REFERENCE: Arborist Response to City Review Comments RE: SUB22-009 (Cui Preliminary Short Subdivision)

SITE ADDRESS: 4833 90th Ave SE, Mercer Island, WA

DATE: 8/9/2023

Tree Planting Schedule

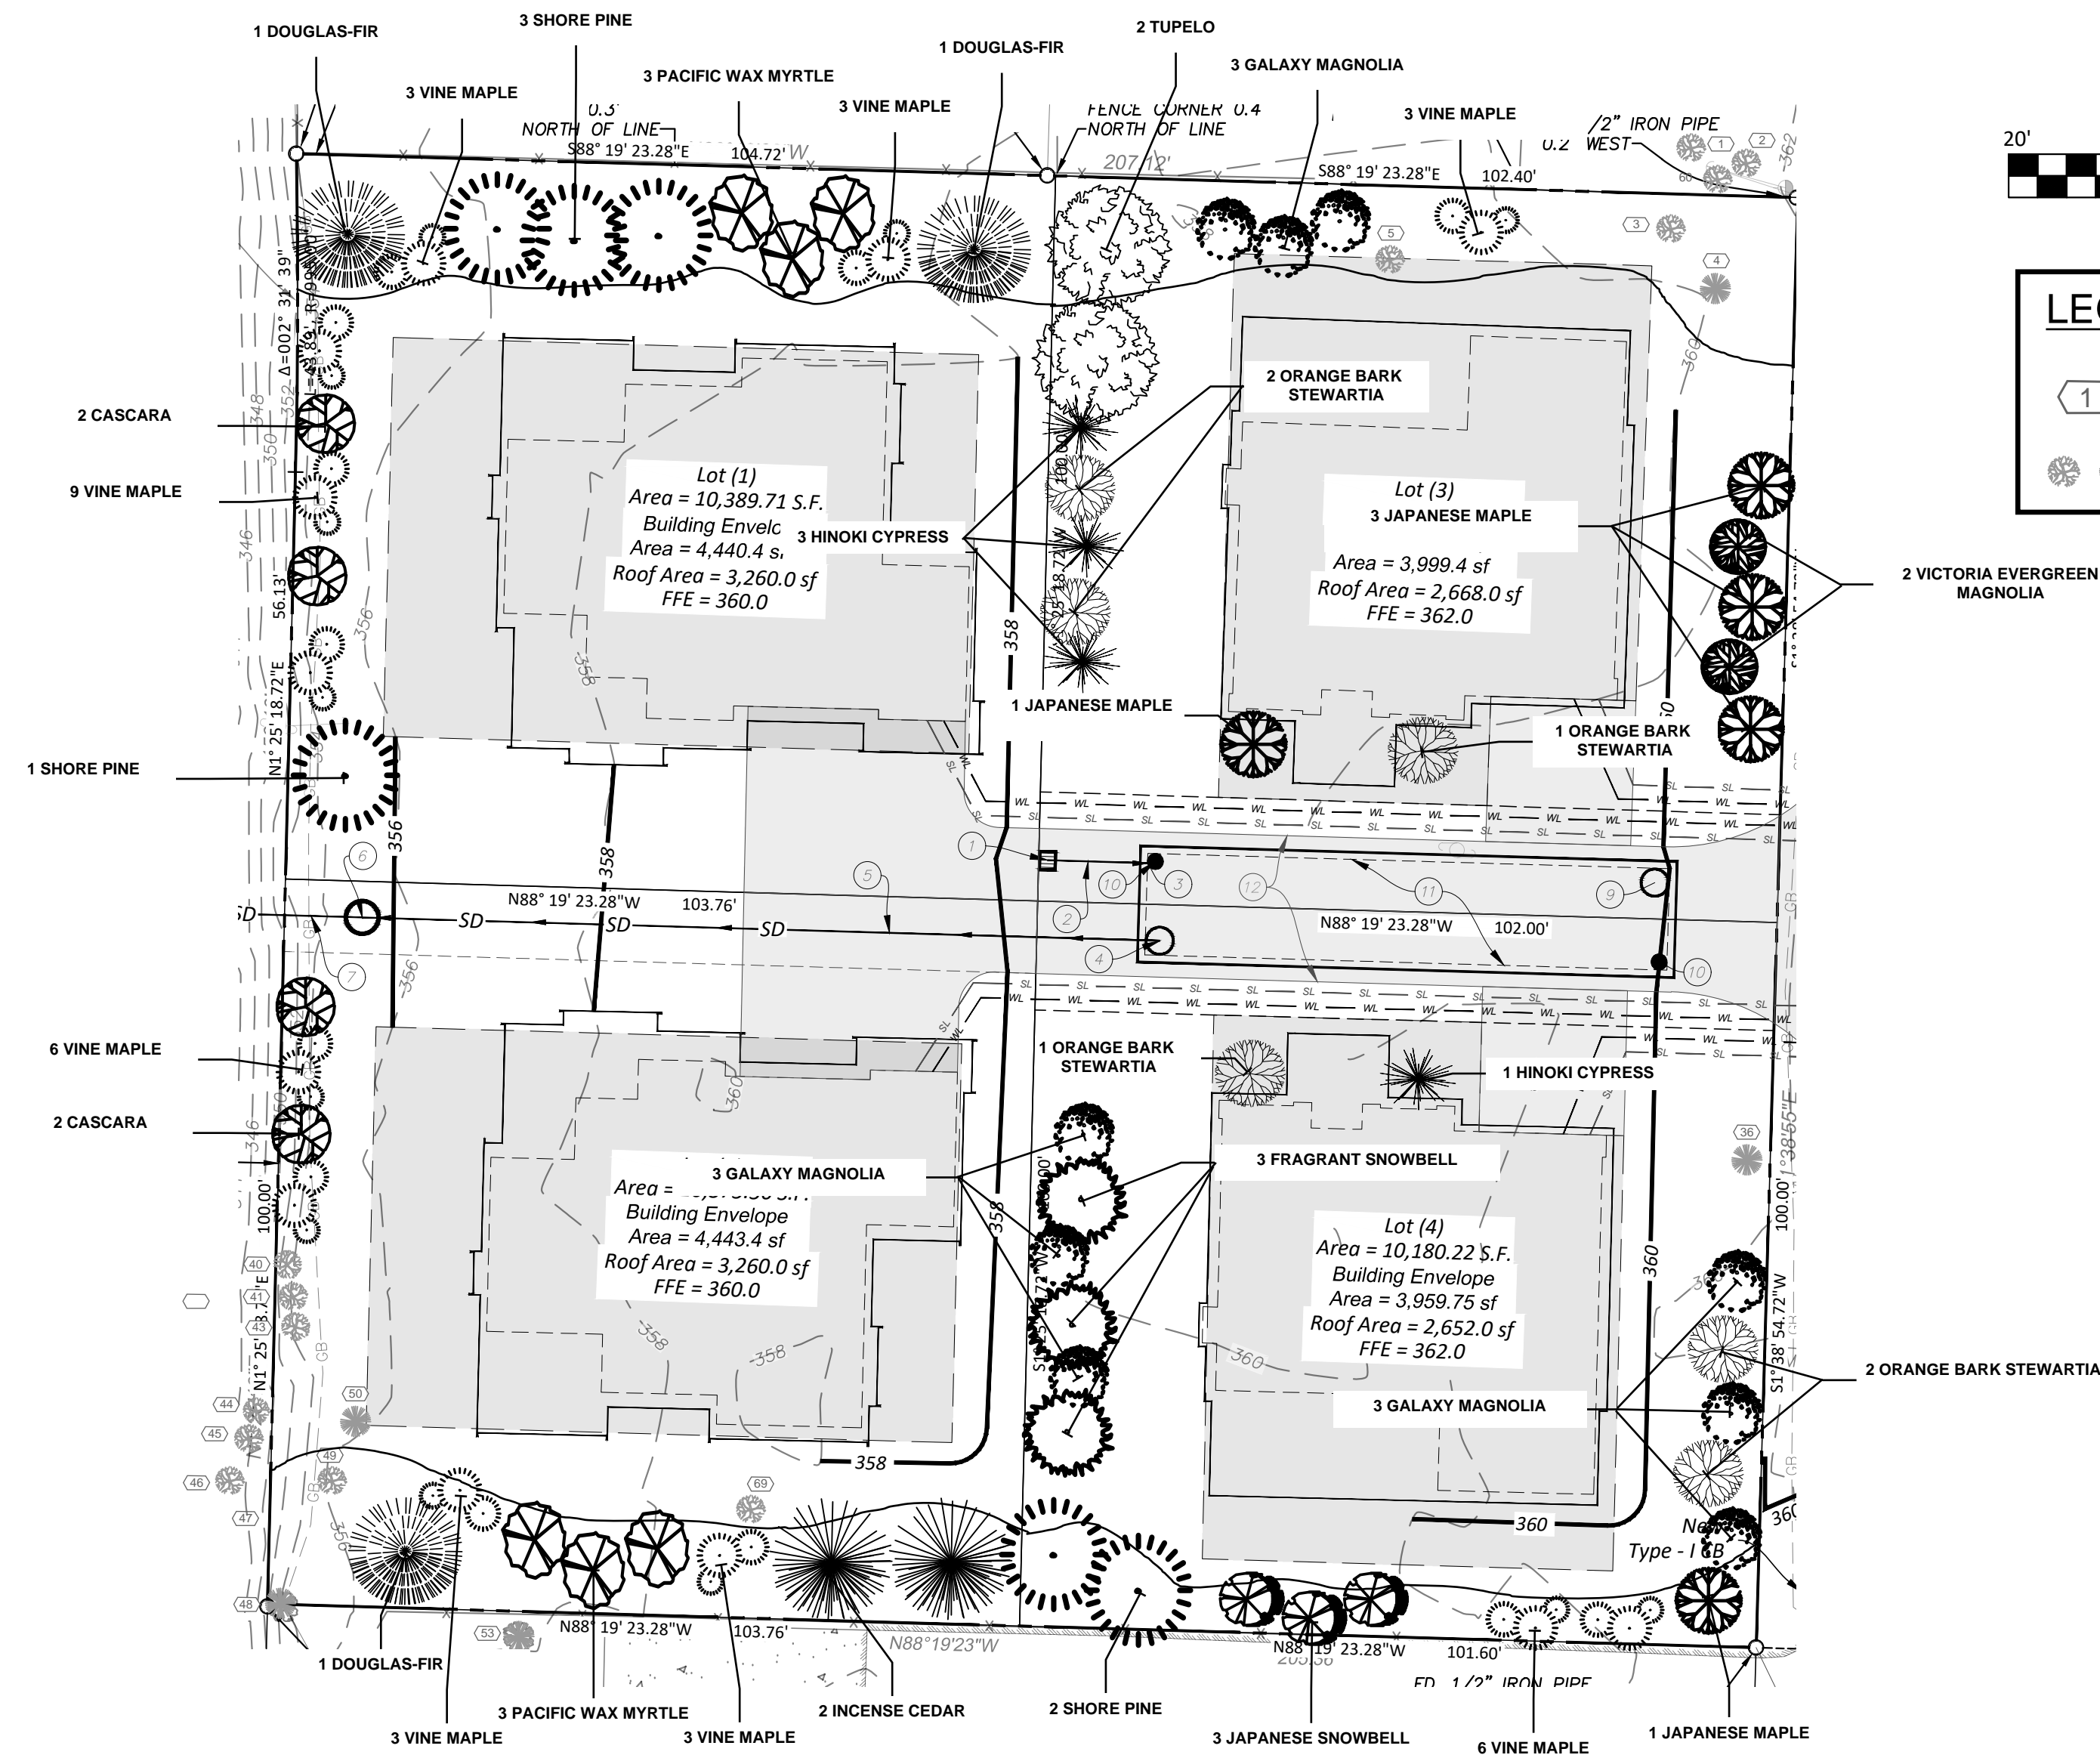
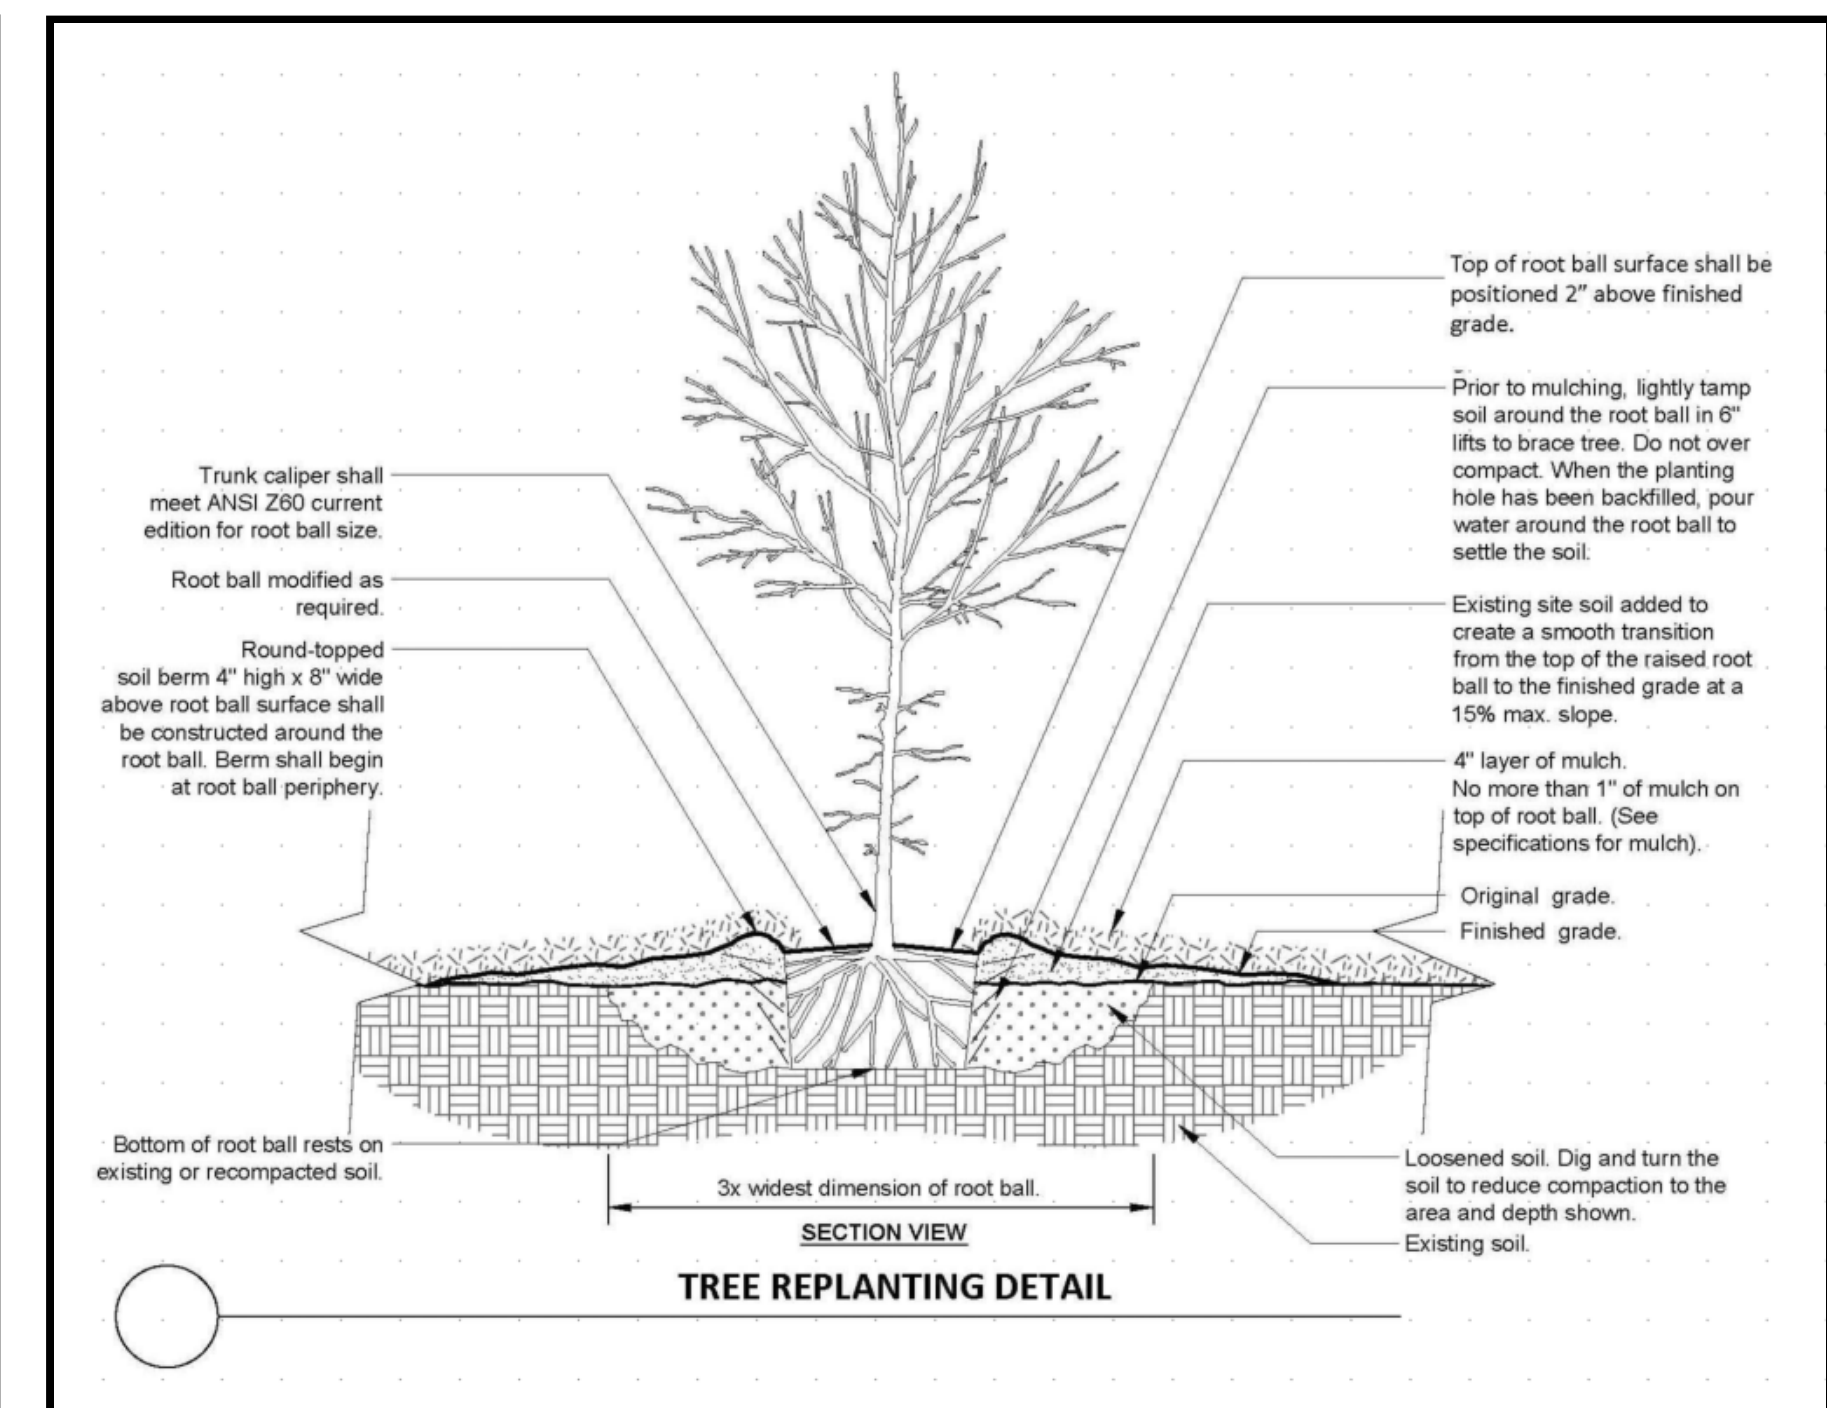
4. *Replacement is required for any trees that are removed according to the replacement ratios set forth in MICC 19.10.070. It appears that most of the property is an exceptional grove. All exceptional trees and exceptional grove trees (even those below 24 inches) must be replaced with six trees. At least half of the trees need to be native to the Pacific Northwest (please see this Native Plant Guide for more information). The trees need to be at least 10 feet apart from each other, structures, fences, and utilities. A fee in lieu of replanting is available upon request after retention requirements are met. A tree watering plan must also be submitted to ensure the trees survive long-term.*
 - a. **Response: This project proposed to replant 90 trees, 52 of which are native tree species. See Tree Planting Plan for more details.**
